Appeal Decision

Appeal Ref: APP/C3105/W/20/3262720

Banbury Service Station, Oxford Road, Bodicote OX15 4AB

- The appeal is made under section 78 of the Town and Country Planning Act 1990 against a refusal to grant planning permission.
 - The appeal is made by Mrs Natalie Ternent against the decision of Cherwell District Council.
 - The application Ref 20/02498/F, dated 11 September 2020, was refused by notice dated 6 November 2020.
 - The development proposed is a single storey rear extension.
-

Drawing No: PLN.065.A3
Scale: 1:100 & 1:1250@ A3
Issue Date: 11/09/2020
Drawn: MK
Checked: KA

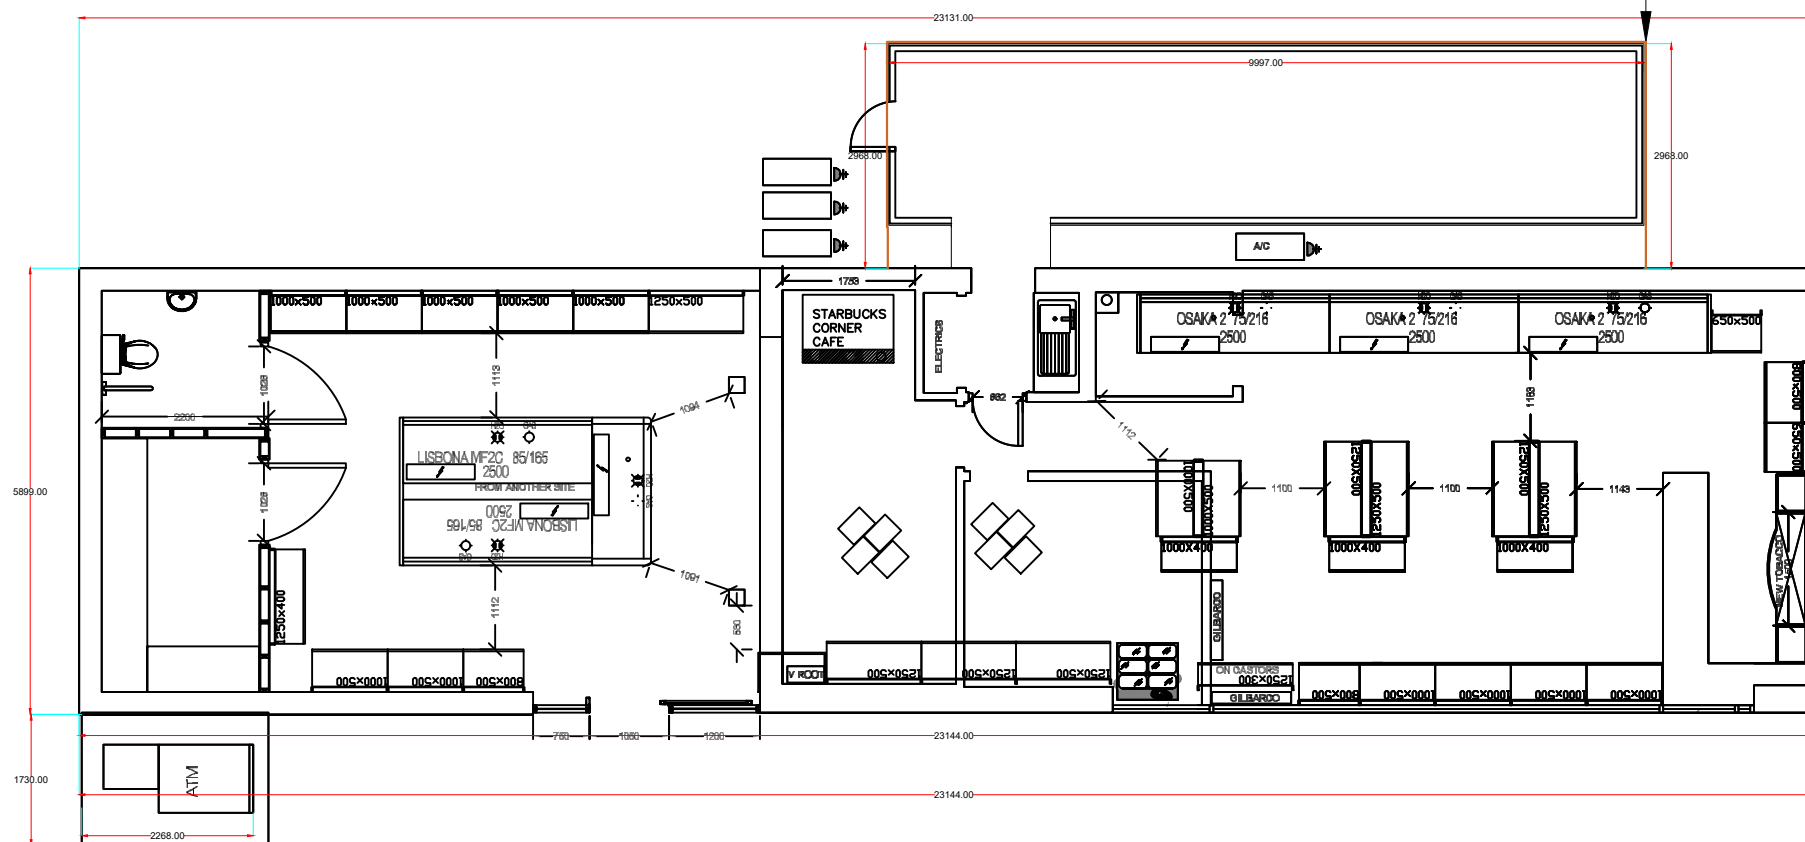
2. Although a storage container of similar dimensions to that shown on the submitted drawings is in situ at the site, it is not finished in the materials shown on the proposed elevations. I have determined the appeal on the basis of the proposed elevations and floor plan.

Drawing No: PLN.066.A3
Scale: 1:100 & 1:1250@ A3
Issue Date: 11/09/2020
Drawn: MK
Checked: KA

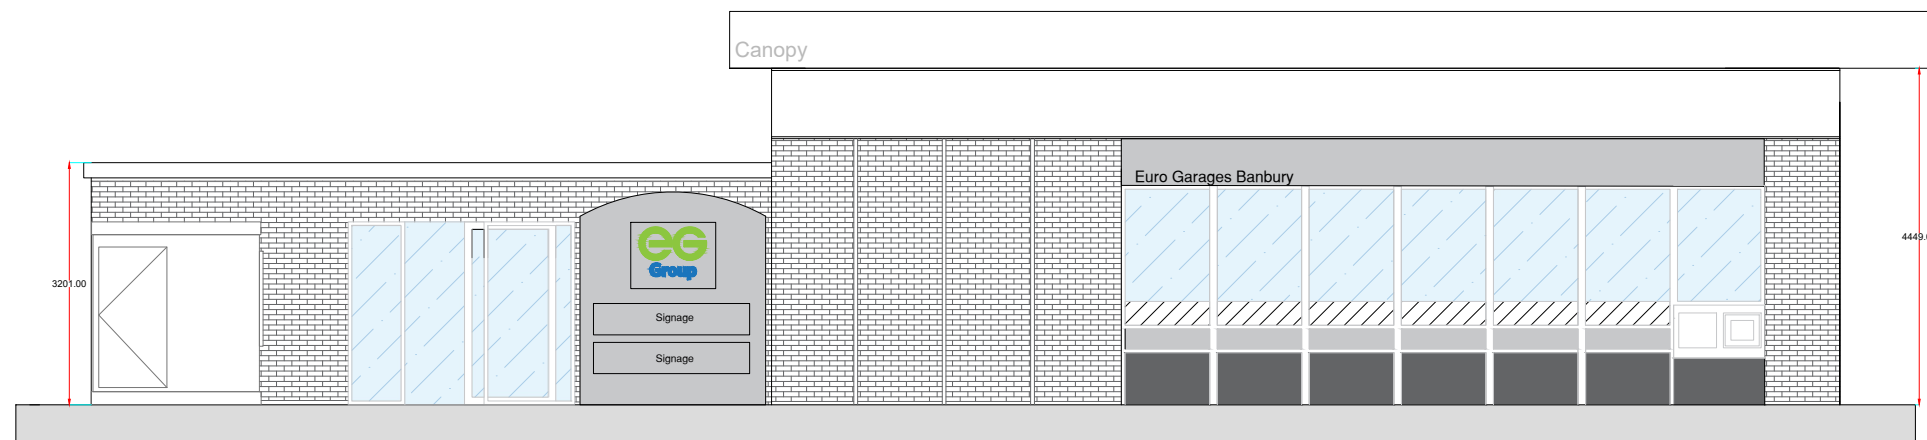
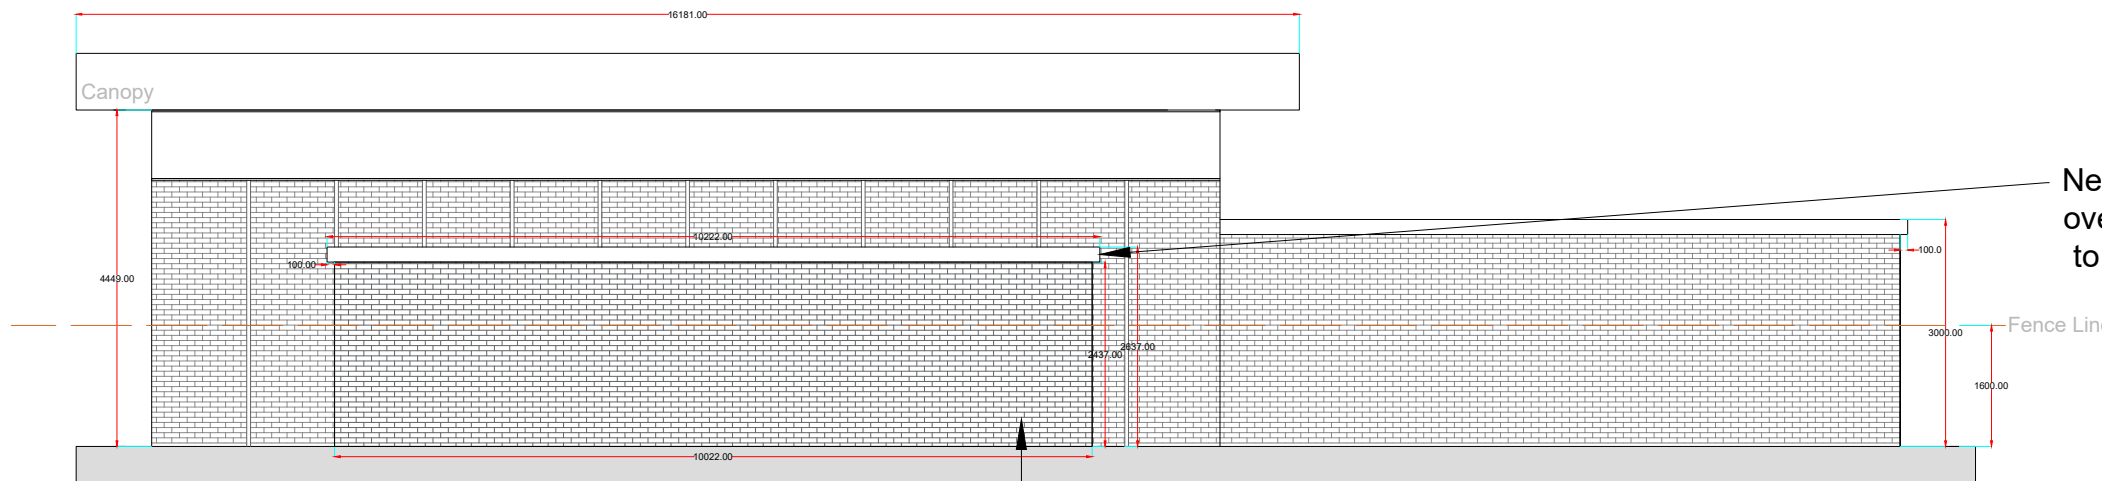
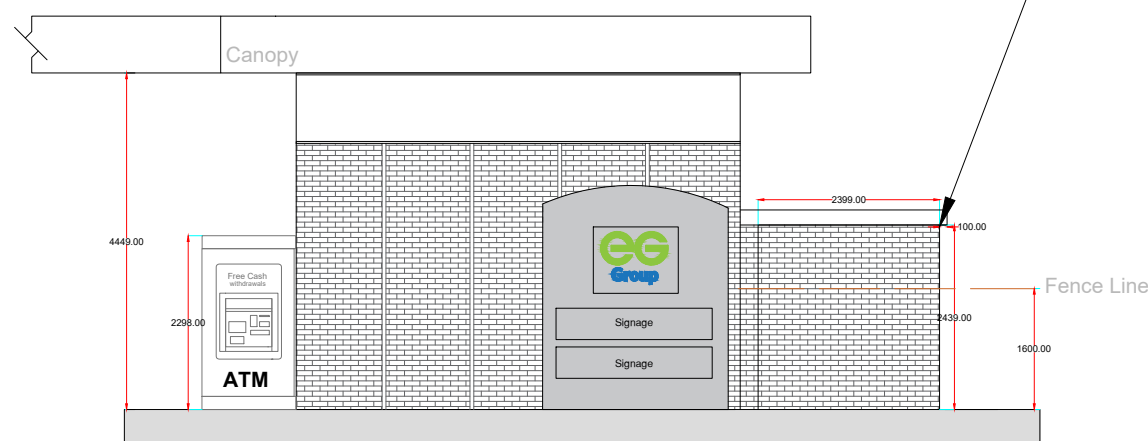
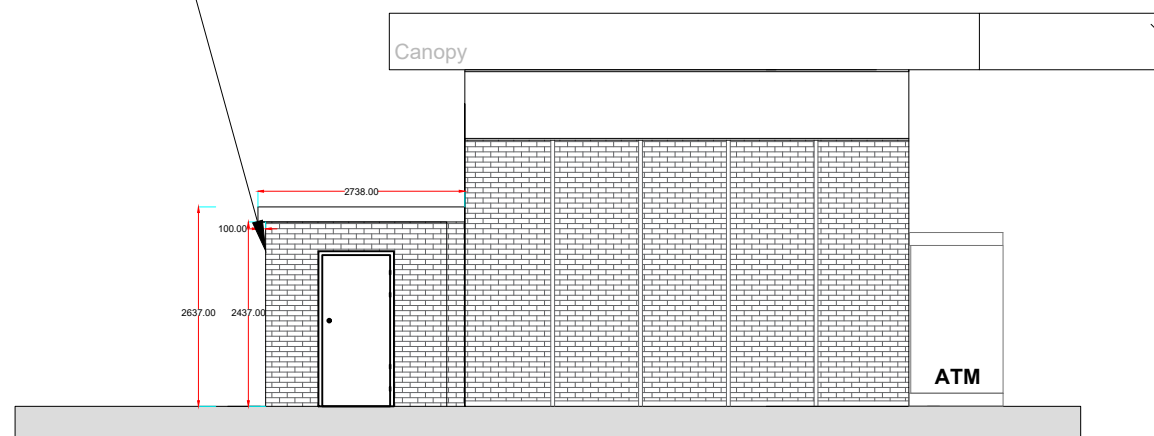
6. The proposal would retain an existing storage container sited to the rear of the kiosk building. Although the structure had temporary permission¹ for 3 years, this has now expired. It is proposed to finish the container unit with brick slips, white fascia and grey roof to broadly match the main kiosk building. Nevertheless, it would retain standardised boxlike dimensions and would have a rudimentary connection with the main kiosk building. Furthermore, there would be a height difference with both components of the existing kiosk building. In combination these factors would result in a harmful disjointed and cluttered appearance. My finding on this is consistent with that in the recent previous appeal decision² at the site which sought to retain the storage container.

7. Furthermore, the addition of the white fascia at eaves level would draw the eye and emphasise the negative impact. Although it would be set back and lower in height than the main kiosk building, as it would be higher than the boundary fencing³, it would be seen from Oxford Road, the lay-by and the adjacent dwelling to the south east.

³ Fence line on drawing no. PLN.066.A3

12. Reference is made to the flat roof and proposed materials reflecting that seen on the kiosk and canopy. These factors would limit the extent of the harm which I have acknowledged would be small. Nevertheless, for the reasons already outlined, they would not fully overcome my concerns nor make the proposal policy compliant.
